The Drovers Solar Farm

Statement of Common Ground (SoCG) with Environment Agency (Tracked)

Document reference: APP/5.13.2 (Revision 2)

DRAWING TITLE:
Figure 12.15: Work No. 4 Maximum Potential Foundations and Groundwater Elevations

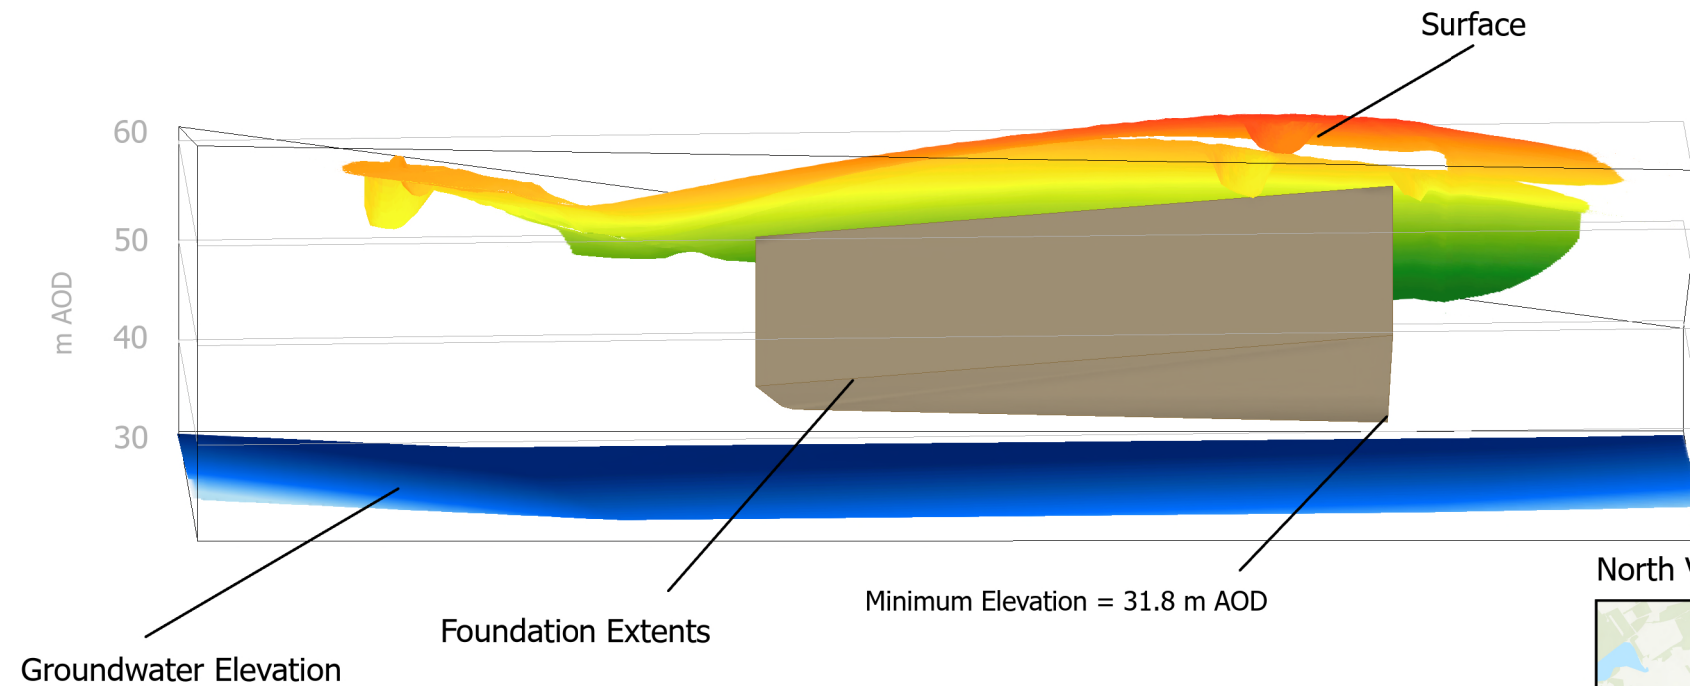
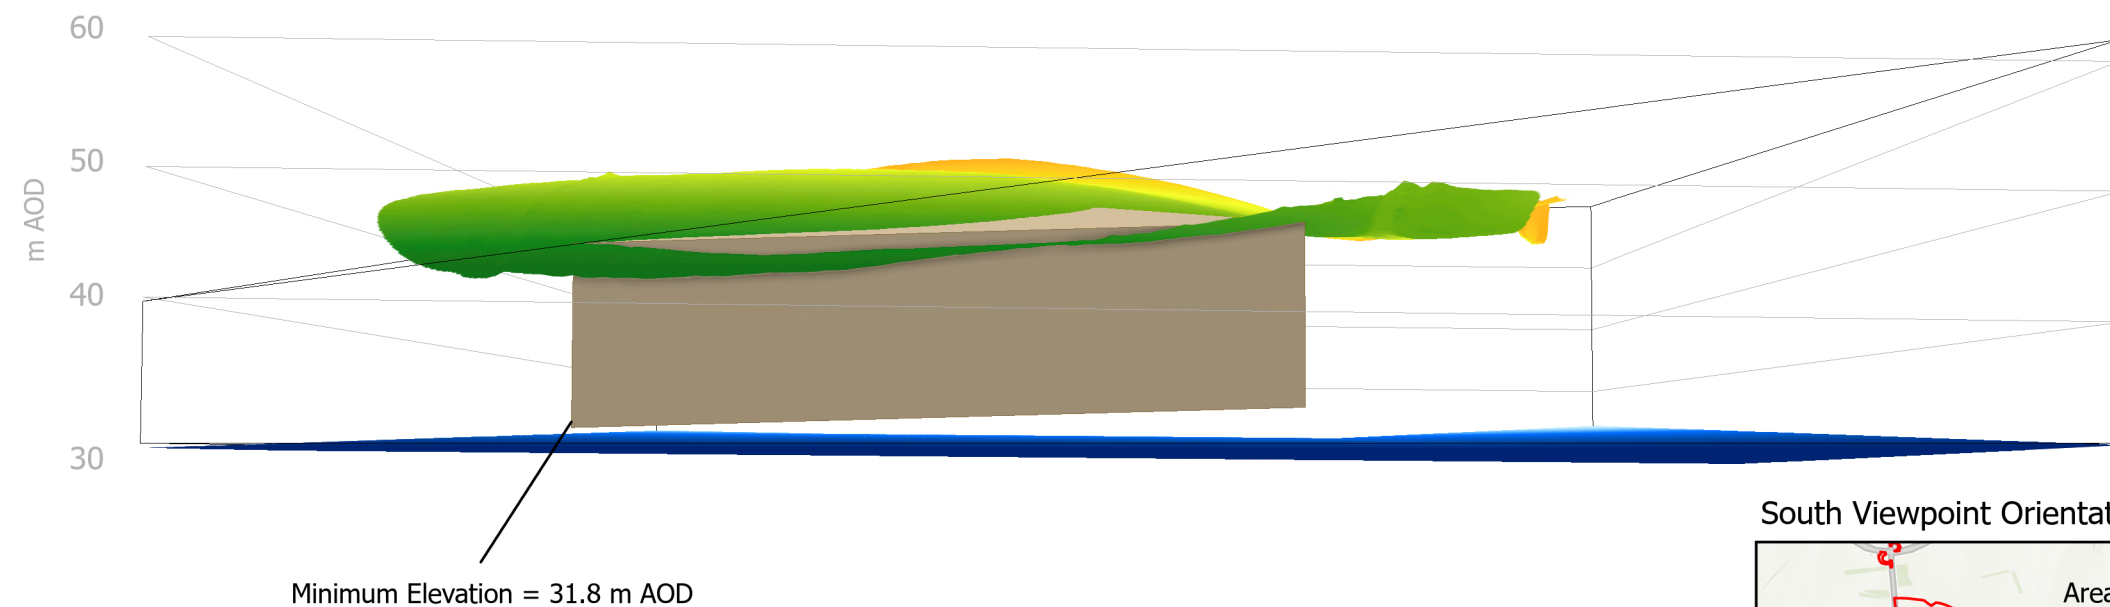
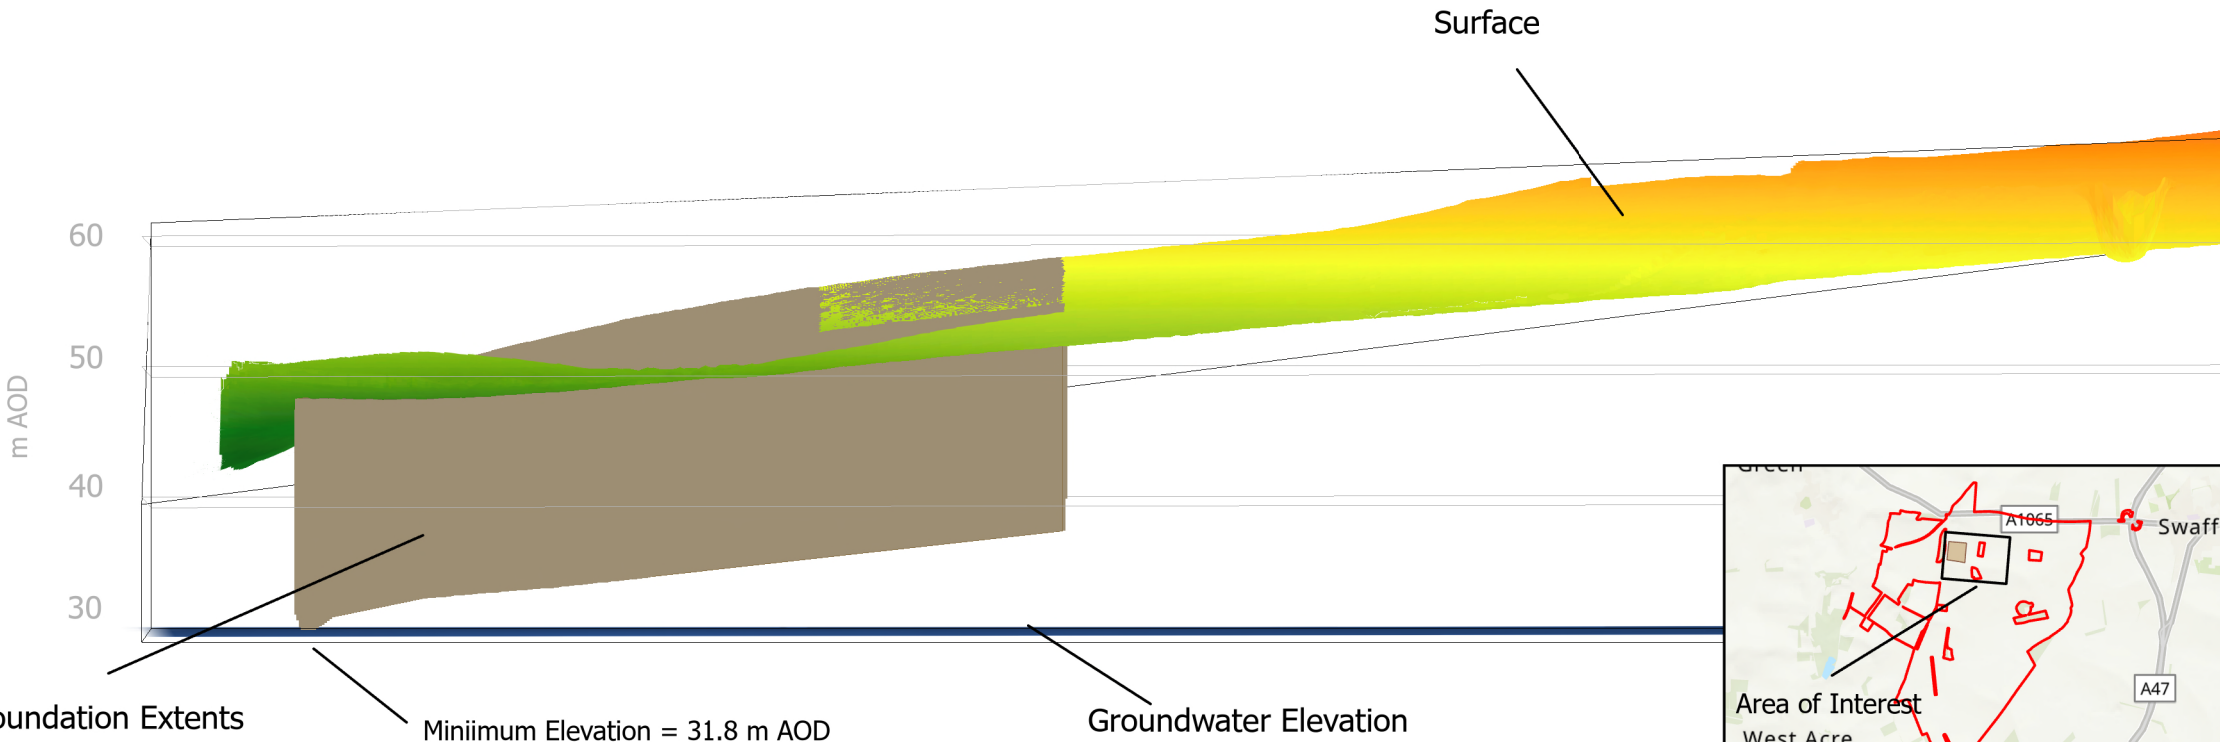
Figure 12.14 Work No. 3 Piling Locations within CSA for Maximum Groundwater Level [APP 128]– Figure 12.15 Work No. 4 Piling Locations within CSA for Maximum Groundwater Level [APP 129]– Figure 12.16 Maximum Foundation Extents for Minimum Groundwater Level [APP 130]– Issue: Figures 12.13 to 12.16 do not clearly show the orientation of each 3D model view, and the elevation of the maximum extent of foundations is not given.– Impact: Difficulty in interpreting figures.– Solution: Revise figures to more clearly define the area represented in the drawings, including view orientation, and the maximum foundations extent should be shaded to show elevation values. The model should be updated to inform detailed foundation design, based on site specific survey and monitoring data.– Additional Comments: Use of inconsistent terminology may also result in confusion. Figures 12.13 to 12.15 are titled to show the anticipated extent of piling in comparison with the maximum groundwater level. In the context of the data presented, the maximum groundwater level in mAOD represents the shallowest extent and therefore worst-case condition for groundwater. For clarity the	proposed foundation depths could theoretically intercept shallow groundwater under worst-case conditions. The figures also demonstrate at a concept level where piling may be required depending on foundation design. The following changes have beenwere made at Deadline 3 to aid the EA's interpretation: • Addition of orientation labels or description • Elevation shading to show mAOD values for the maximum groundwater elevation surface and foundation extent surface • Highlight areas where foundations intersect or exceed groundwater elevation surfaces; and • Figures and text refer to groundwater elevation (mAOD) rather than groundwater level to increase clarity between absolute elevation and depth below ground. The Applicant agrees that the conceptual model present is not the final tool for foundation design, but rather to provide a screening-level assessment of groundwater conditions and to identify areas needing piled or shallow foundations and will be aligned with EA regional groundwater understanding (NEAC model). The Design Principles,

report should preferably refer to groundwater 'elevation' (in mAOD) as is represented within the figures rather than 'level', which could be misinterpreted as relative to ground level rather than Ordnance Datum. Figure 12.16 shows the minimum (i.e. deepest) groundwater elevation (i.e. best case) in relation to anticipated piling depth. Although this is useful information, this could potentially be misinterpreted by the reader as presenting a combined overview of the information provided in Figures 12.13 to 12.15. We are satisfied and consider this issue resolved. We were concerned that figures 12.13 [APP-127], 12.14 [APP-128], 12.15 [APP-129] and 12.16 [APP-130] do not clearly define the area represented by the drawings, including view orientation, or the elevation values. We have reviewed the following: • 6.3.1 ES Figure 12.13 Work No. 2 Maximum Potential Foundations and Groundwater Elevation [REP3-043] • 6.3.1 ES Figure 12.14 Work No. 3 Maximum Potential Foundations and Groundwater Elevation [REP3-044]	Parameters Commitments [APP/5.8.34] have been<u>was</u> updated at Ddeadline 2 to commit to foundations not directly interacting with groundwater. <u>The Applicant maintains the position that a potential interaction of up to 1 m has been determined for a very small section of Work No. 4 and that Figure A12-1-10 displays this minimal interaction northeast of Work No. 4, should the full Work No. be developed.</u>

• <u>6.3.1 ES Figure 12.15 Work No. 4 Maximum Potential Foundations and Groundwater Elevation [REP3-045]</u> <u>We find the updated figures satisfactory for defining the 3D model view, and elevation the maximum extent of the foundations</u>		
2-2	EA38	Storage of Waste Batteries	<u>We are satisfied and consider this issue resolved.</u> <u>We were concerned that there was an absence of mitigation measures relating to the storage of waste batteries.</u> <u>The 7.14.1 outline Battery Safety Management Plan (Tracked) [REP3-072] has been updated to include suitable measures. We cannot resolve this issue. We were concerned that there was an absence of mitigation measures relating to the storage of waste batteries. The Applicant has stated in 8.4 Applicant's Response to Relevant Representations [REP1-067]: "End-of life or damaged BESS units are to be electrically disconnected from the system when identified as being required. When disconnecting damaged or defective units, a specific risk assessment shall be conducted prior to the removal of the defective module to ensure the safety of employees and contractors. Damaged or defective units will be inspected and placed in an approved protective container prior to being</u>	An outline Battery Safety Management Plan (oBSMP) [APP/7.14.2APP-194] has been prepared as part of the DCO Application which sets out the mitigation measures to be secured via Requirement 6 of the draft DCO [APP/3.1.14]. <u>The oBSMP [APP/7.14.2] has been updated at Deadline 4 to confirm the management of damaged or end-of-life batteries by the following:</u> End-of-life or damaged BESS units are to be electrically disconnected from the system when identified as being required. When disconnecting damaged or defective units, a specific risk assessment shall be conducted prior to the removal of the defective module to ensure the safety of employees and contractors. Damaged or defective units will be inspected and placed in an approved protective container prior to being transported from Site, to ensure against any risk of contaminants entering ground- or surface water. End-of-life batteries awaiting	LowAgreed
